The Lake Lothing (Lowestoft) Third Crossing Order 201[*]

Annex A: Environment Agency Consultation

**THIRD RIVER CROSSING, LAKE LOTHING ENVIRONMENTAL STATEMENT -
FLOOD RISK ASSESSMENT METHODOLOGY**

LAKE LOTHING THIRD CROSSING: FLOOD RISK ASSESSMENT AND MODEL FILES

**MAINLINE LONG SECTION
(WORK NOS. 1A, 1B, 1C, 1D & 1E
WORKS PLANS SHEET NOS. 1 & 2)**

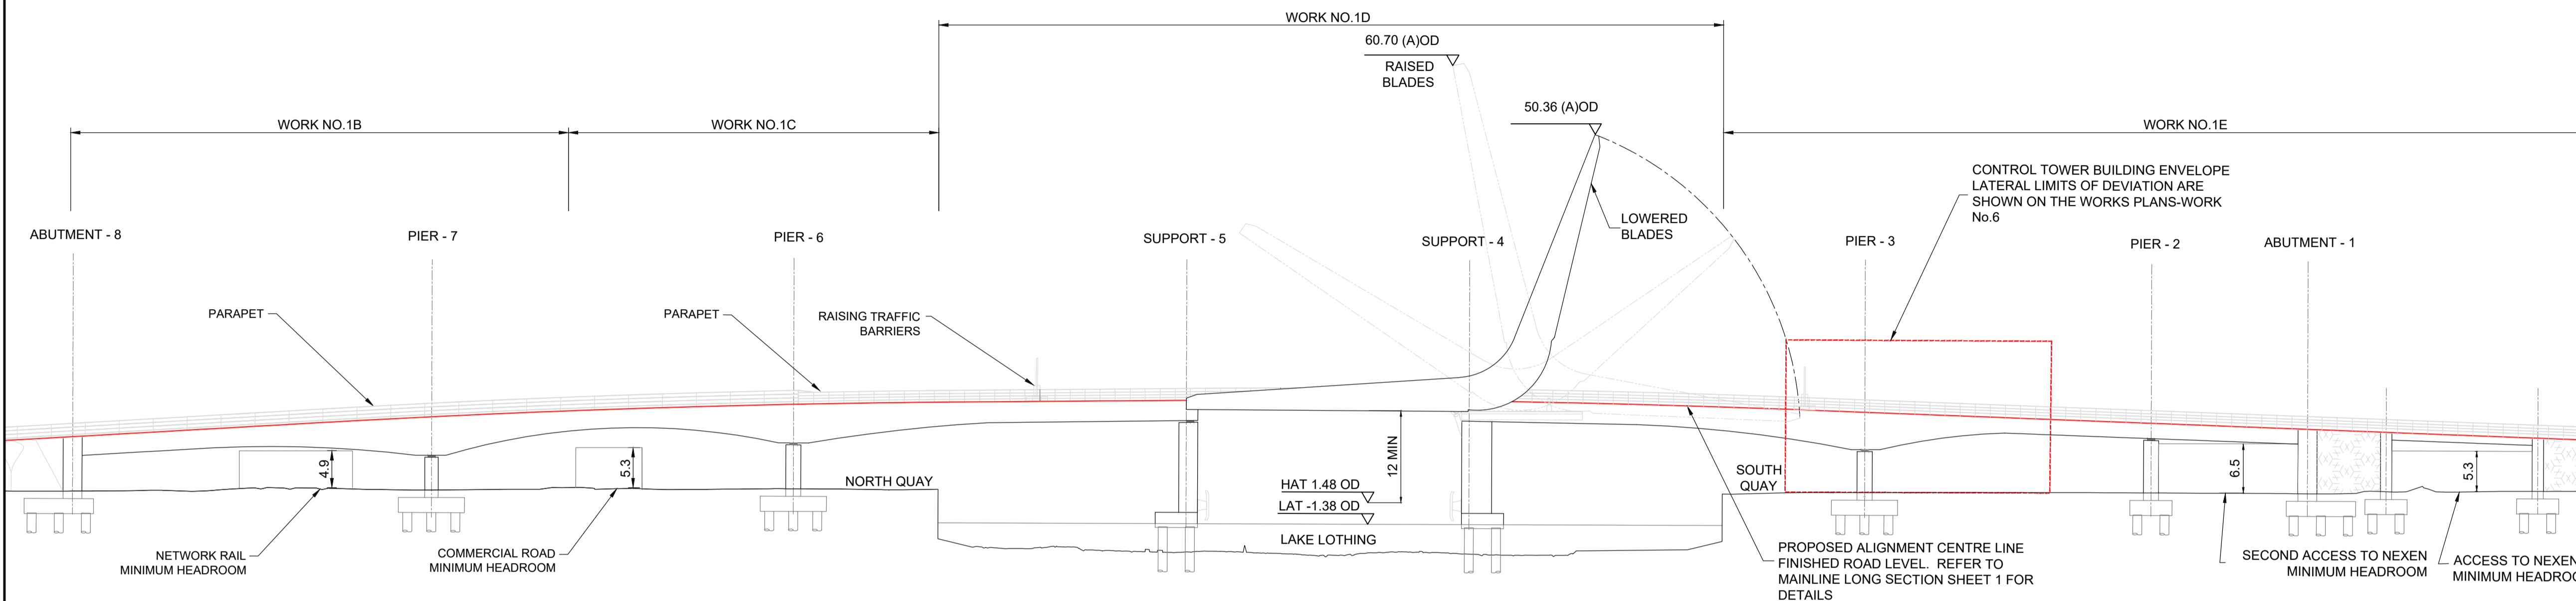
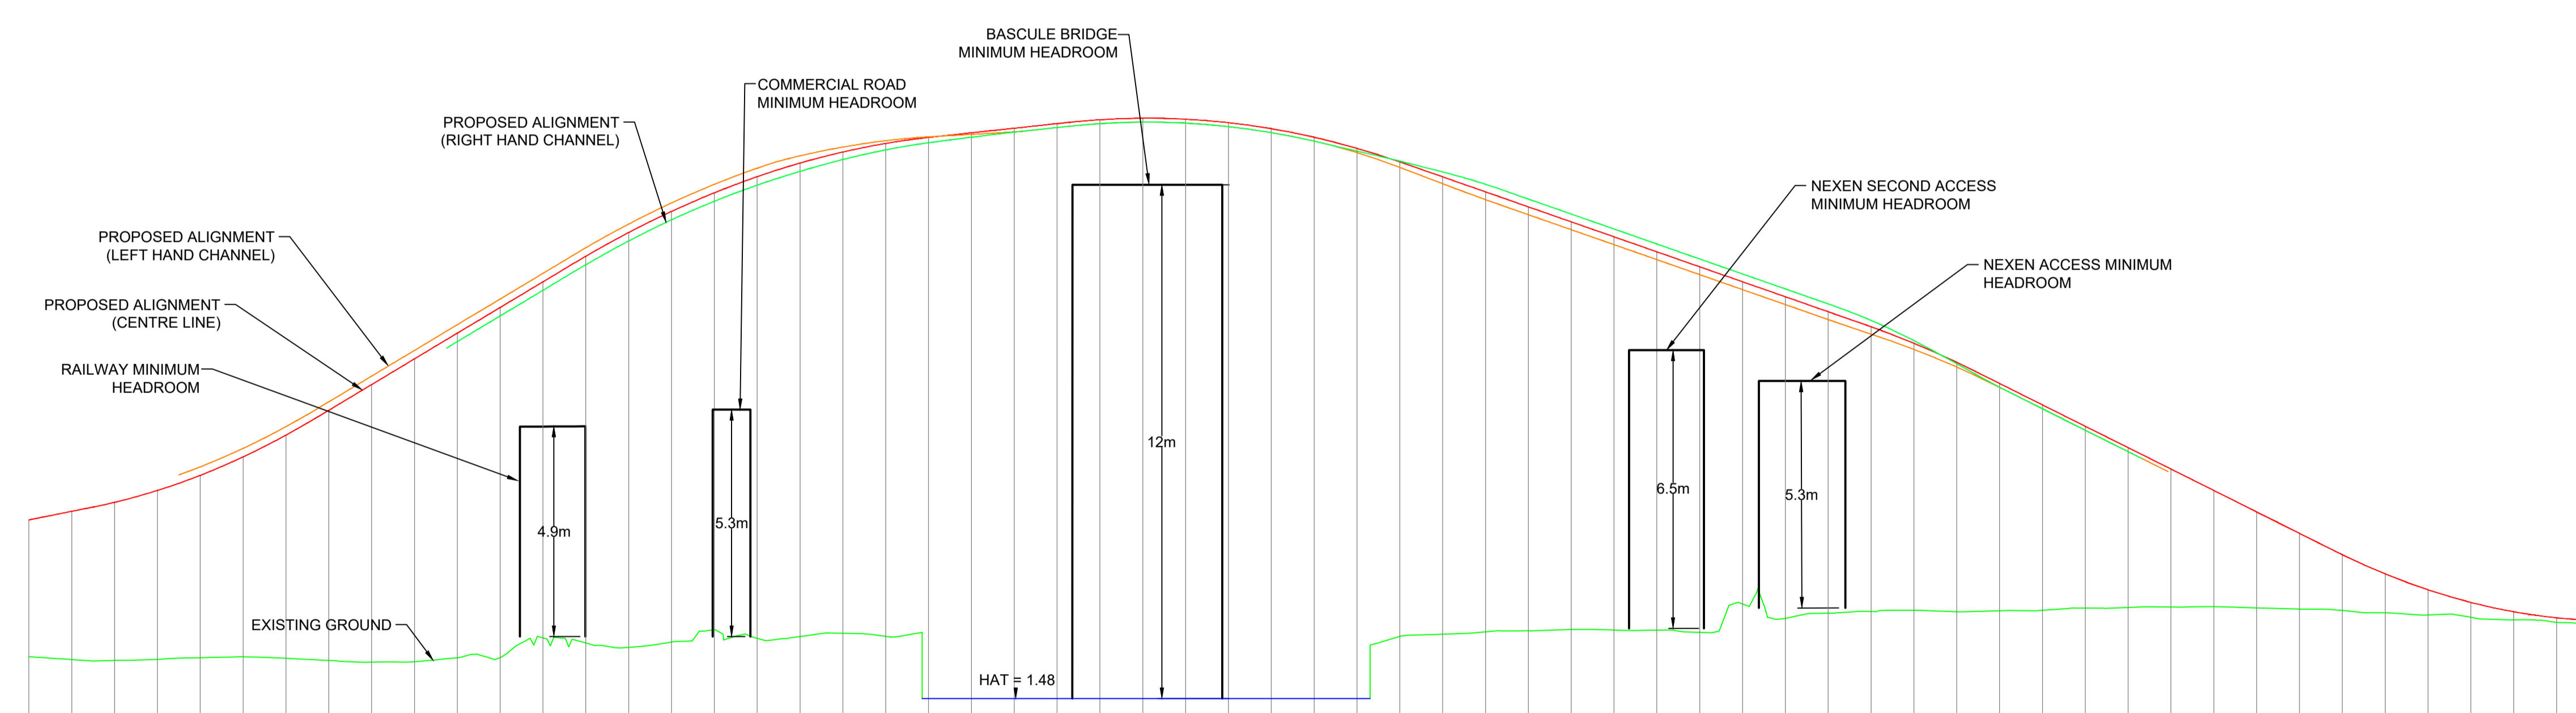
Figure 1-2 shows the proposed road alignment of the C13A crossing design. It would be useful to know if the road network is likely to be raised as this would need to be considered in the FRA. This could remove floodplain storage and alter flood flow paths. Once the design of the bridge has been finalised it would be helpful to include a cross section of the crossing including elevations within the FRA.
